ENG-EGP22006-R1-FDR.pdf Markup Summary

EGP226

Subject: Stormwater Comments Color
Page Index: 1
Date: 3/14/2023 3:26:33 PM
Author: dotprete
Color: ■
Layer:
Space:
Page Label: 1

Culvert Report

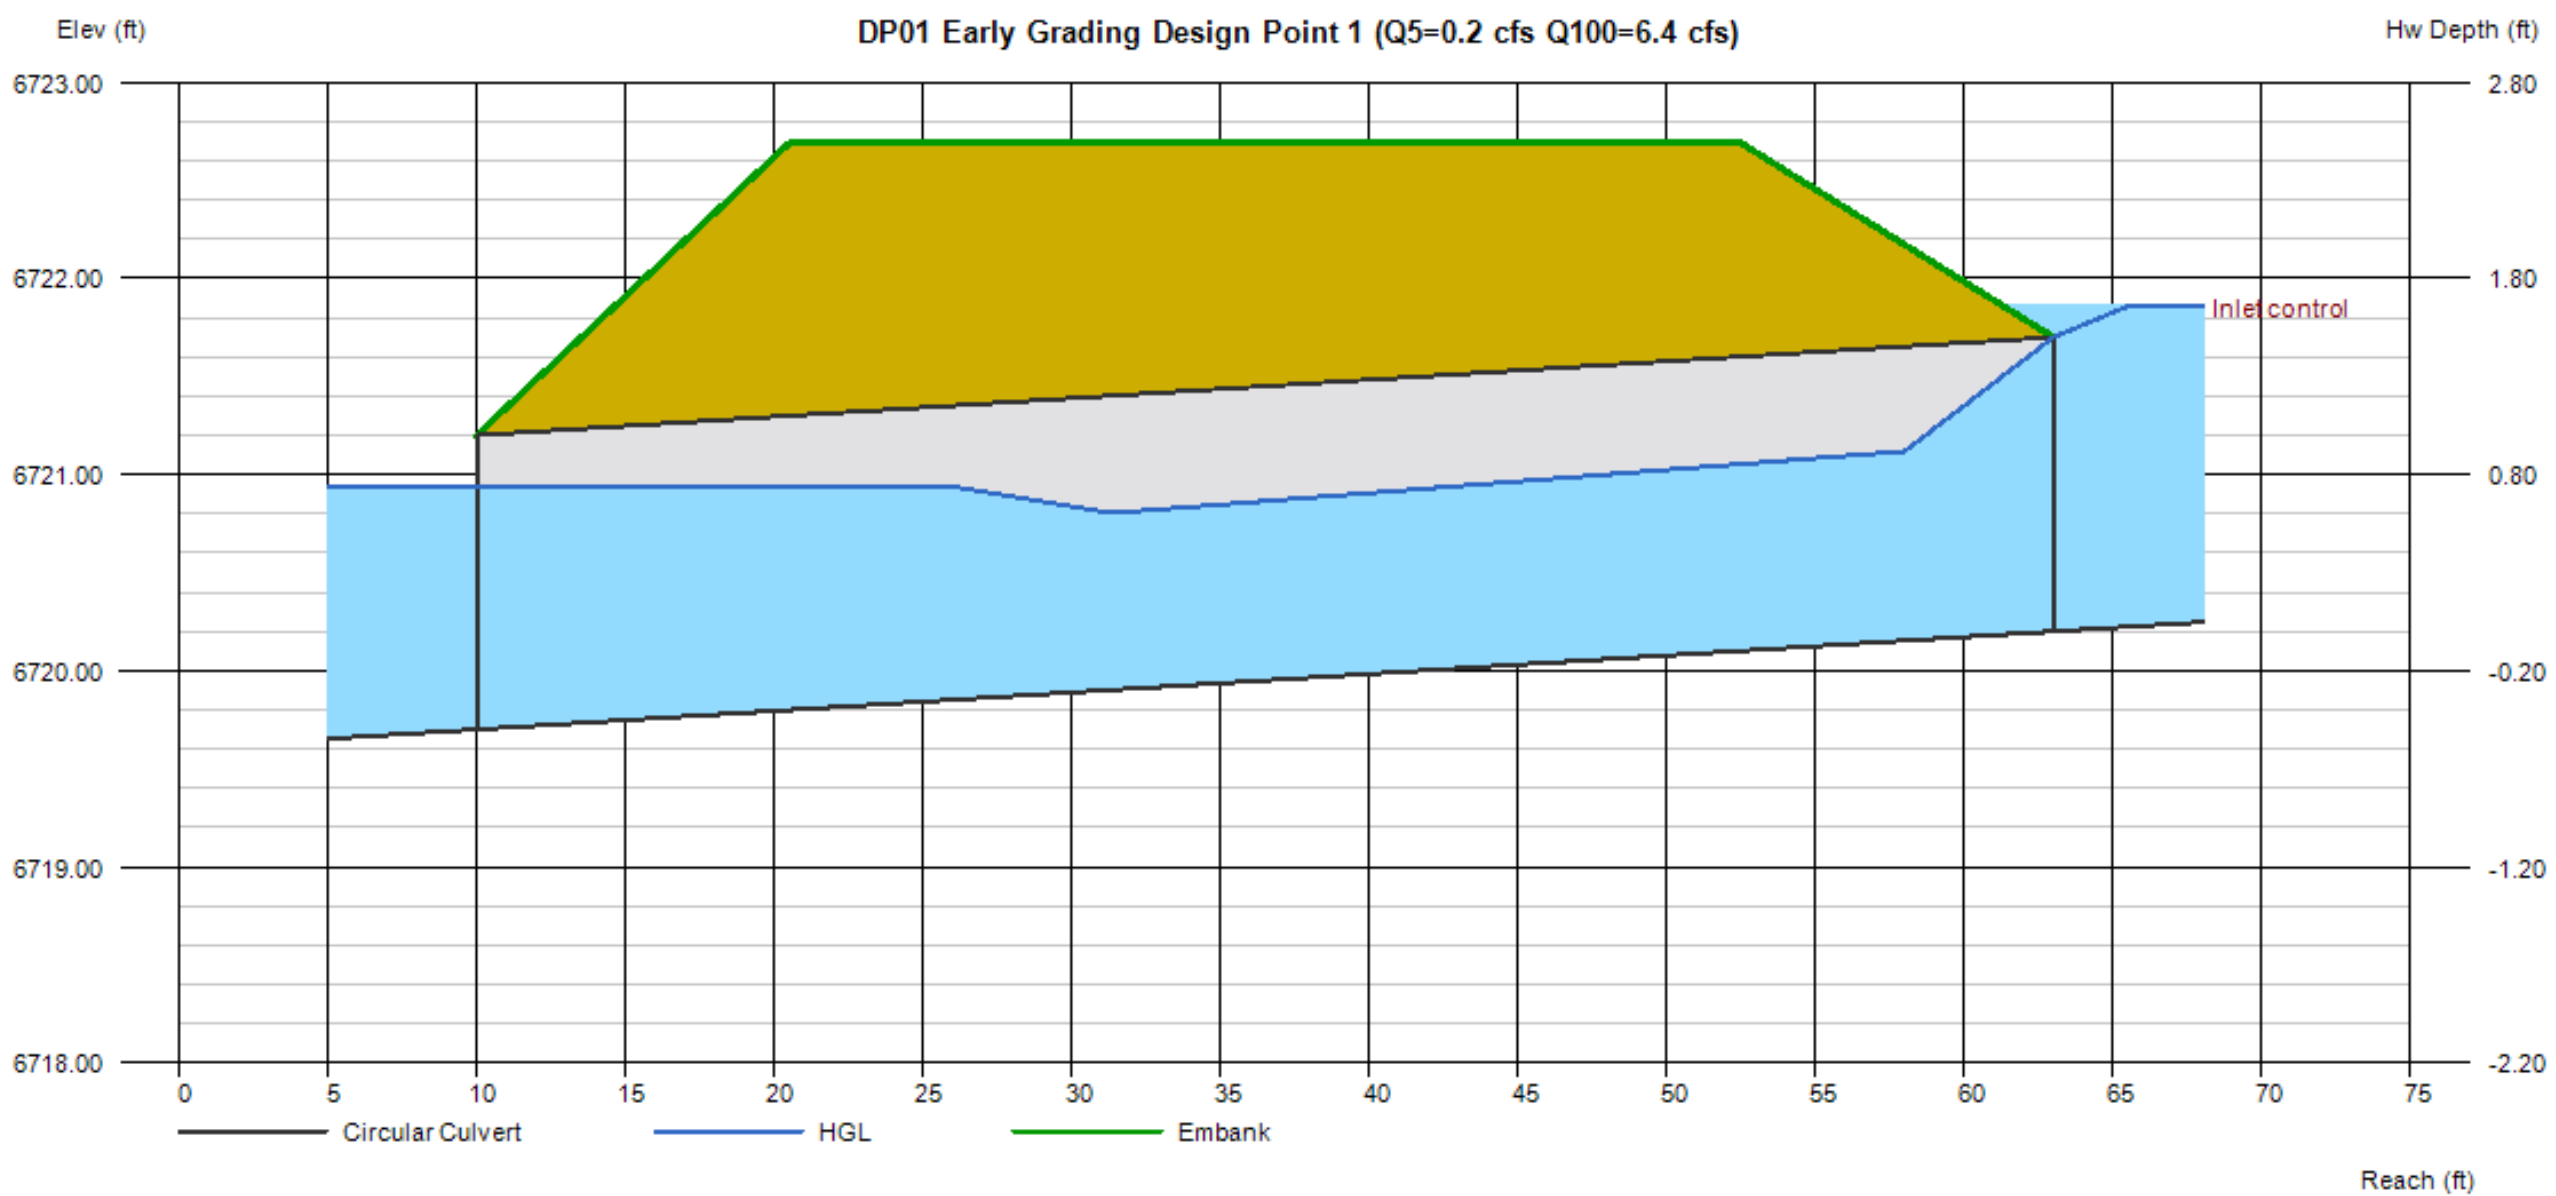
Flows do not match hydrology spreadsheet for DP 1.0. Please update sheet with flows shown on hydrology spreadsheet (0.3 & 11.4 cfs)

DP03 Early Grading Design Point 1.1 (Q5=0.3 cfs Q100=11.4 cfs)

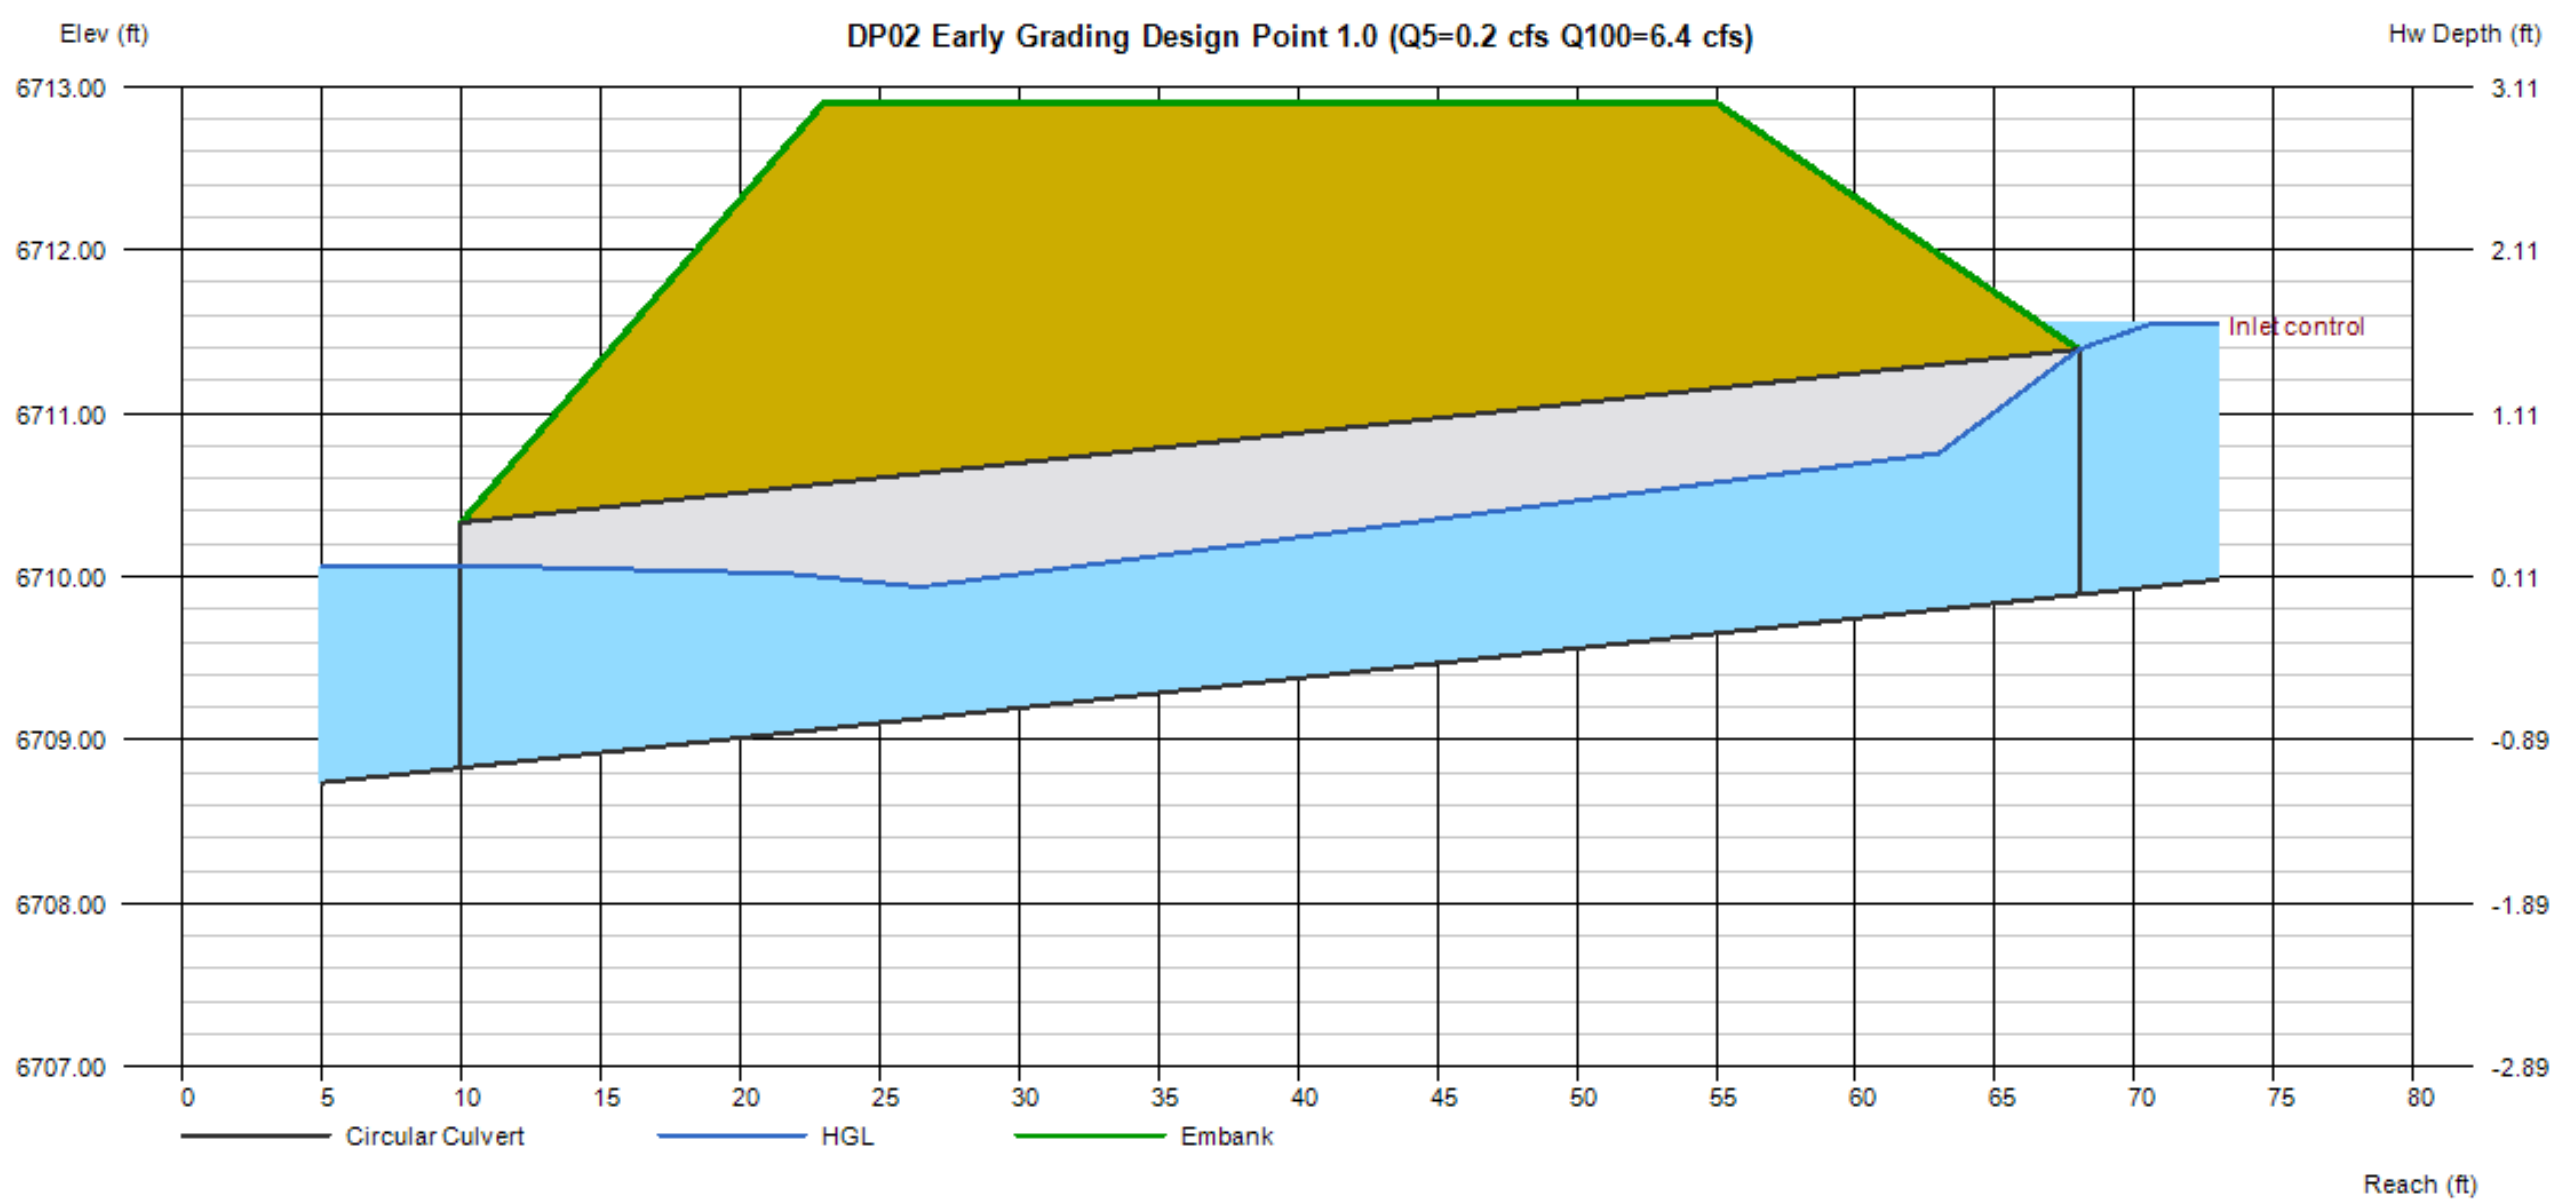
Flows do not match hydrology spreadsheet for DP 1.1. Please update sheet with flows shown on hydrology spreadsheet (0.4 & 15.2 cfs)

SADDLEHORN FILING 5 EARLY GRADING PROPOSED DRAINAGE MAP

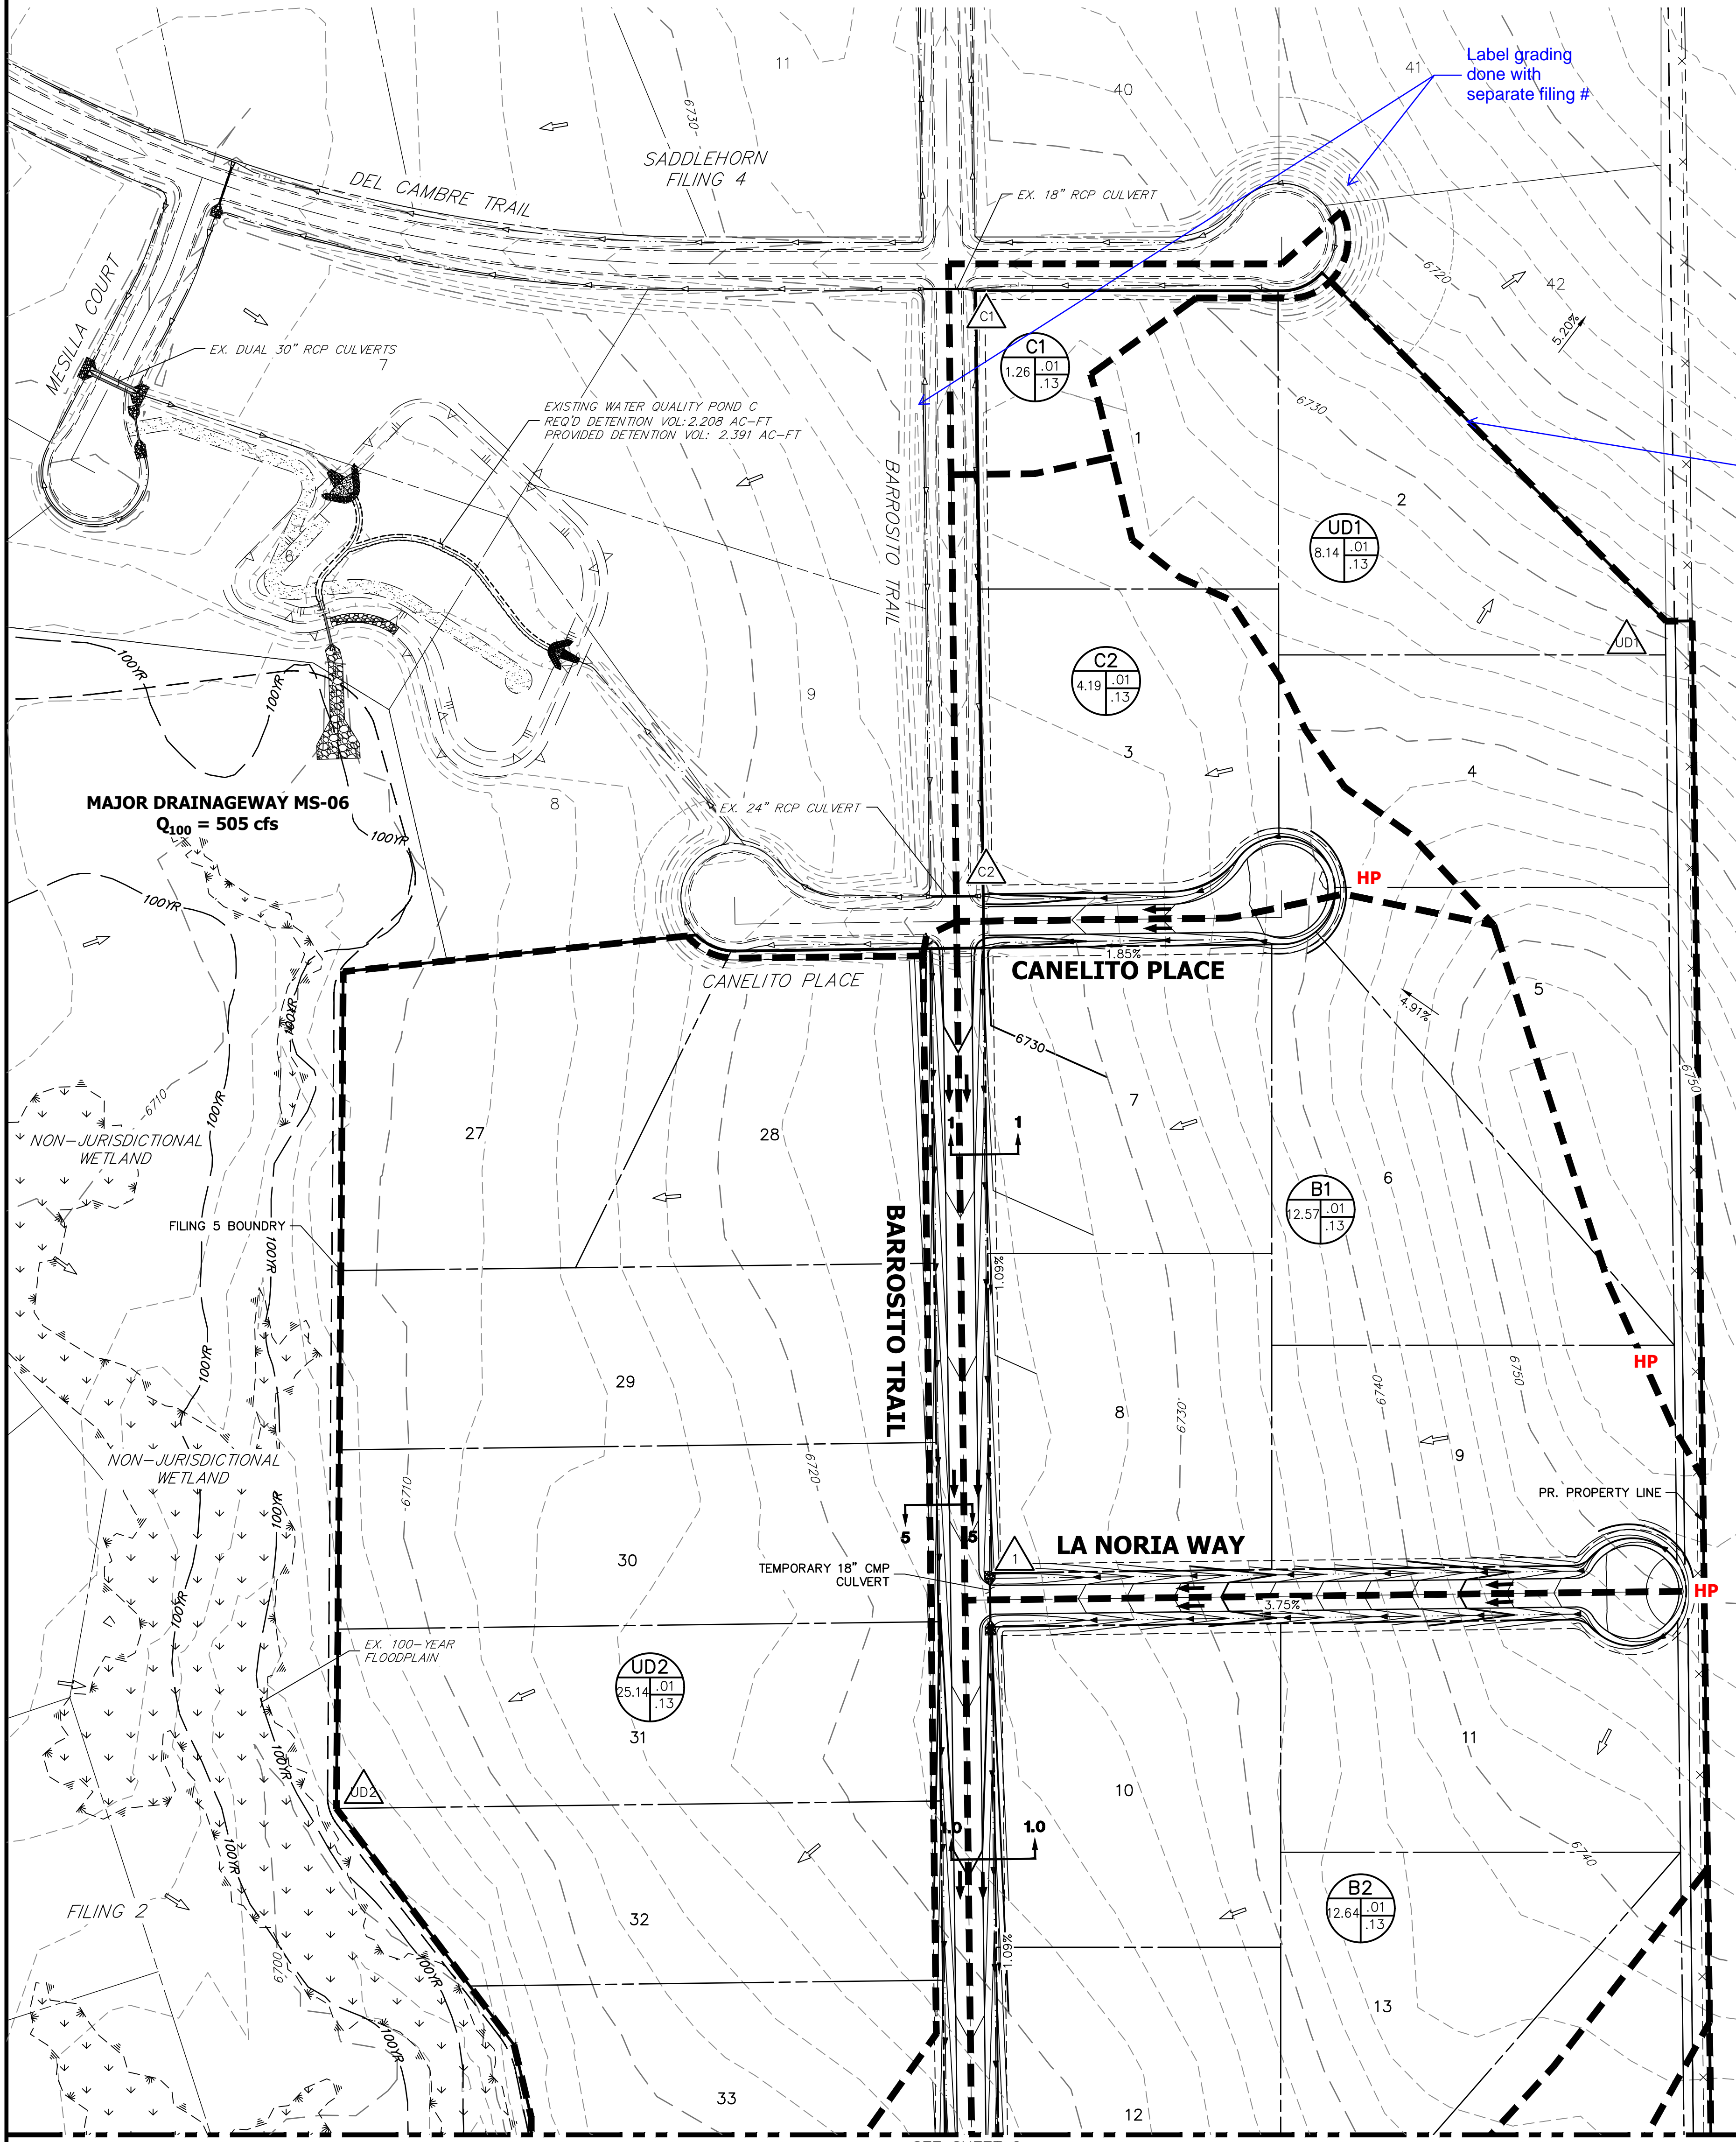
Provide offsite basins

Label grading done with separate filing #

Label adjacent property owners

Extend decimal place

Label basin ended at property line for analysis purposes
